Subject: **Review of Grading Plan**
Proposed Mercer Island Bike Skills Area
Deane's Childrens Park
5650 Island Crest Way
Mercer Island, Washington

As required by the City of Mercer Island in their July 26, 2023 *First Review Letter*, a grading plan for the trails to be completed for the Bike Skills Area has been prepared. This plan has been developed by Station 10 Engineering and Design, and is dated August 23, 2023.

Rev #	Date	Description
1	8/23/23	Grading Plan

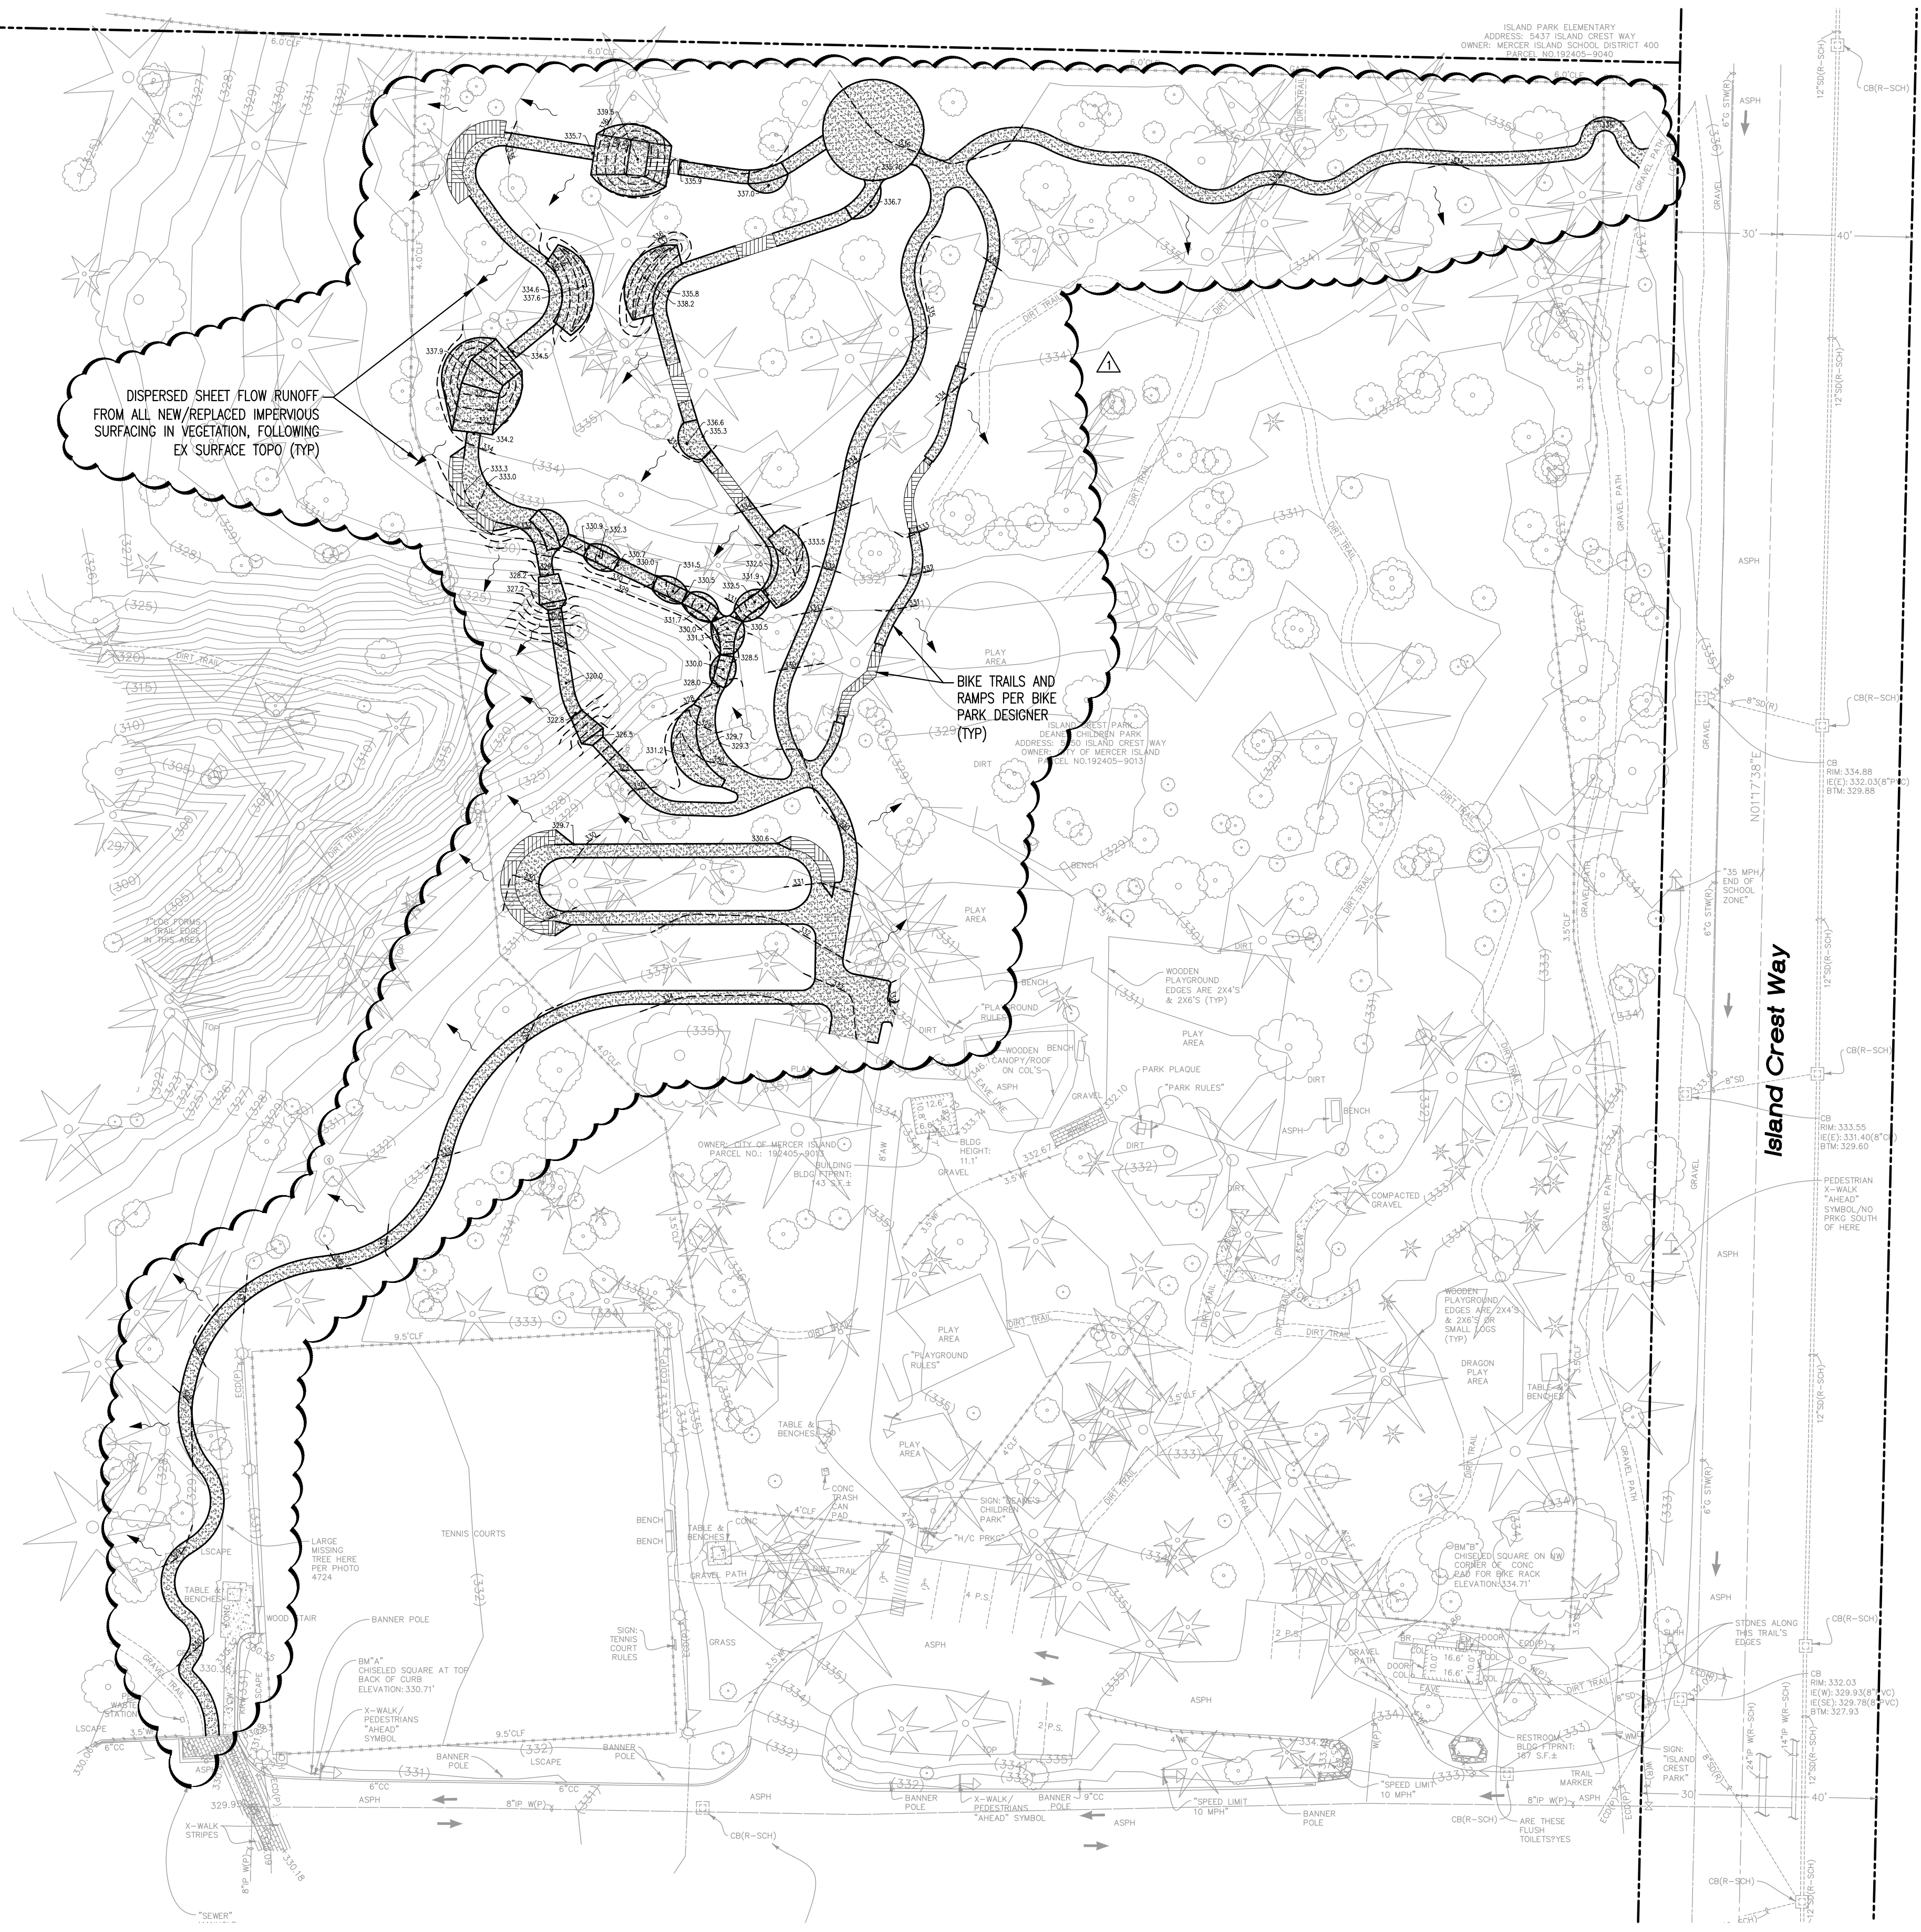
In conformance with our recommendations, the plan has limited any potential fills within, or near, the western ravine feature to 12 inches. A previously-planned berm located on top of the north sidewall of the ravine has been modified to a wood ramp to avoid a thicker fill along the top of the slope. The placement of these minimal fills on the short ravine slope will not adversely affect the stability of the underlying glacially-compressed soils. As noted in our previous report, this is evident from the well-used footpath located in the ravine downslope of the proposed Bike Skills Area. Similar to the proposed bike trail, this footpath has a thin fill section along its downslope edge to create a more level cross-section for the path.

“It is our professional opinion that the development practices proposed for the new development would render the alteration as safe as if it were not located in a geologic hazard area.”
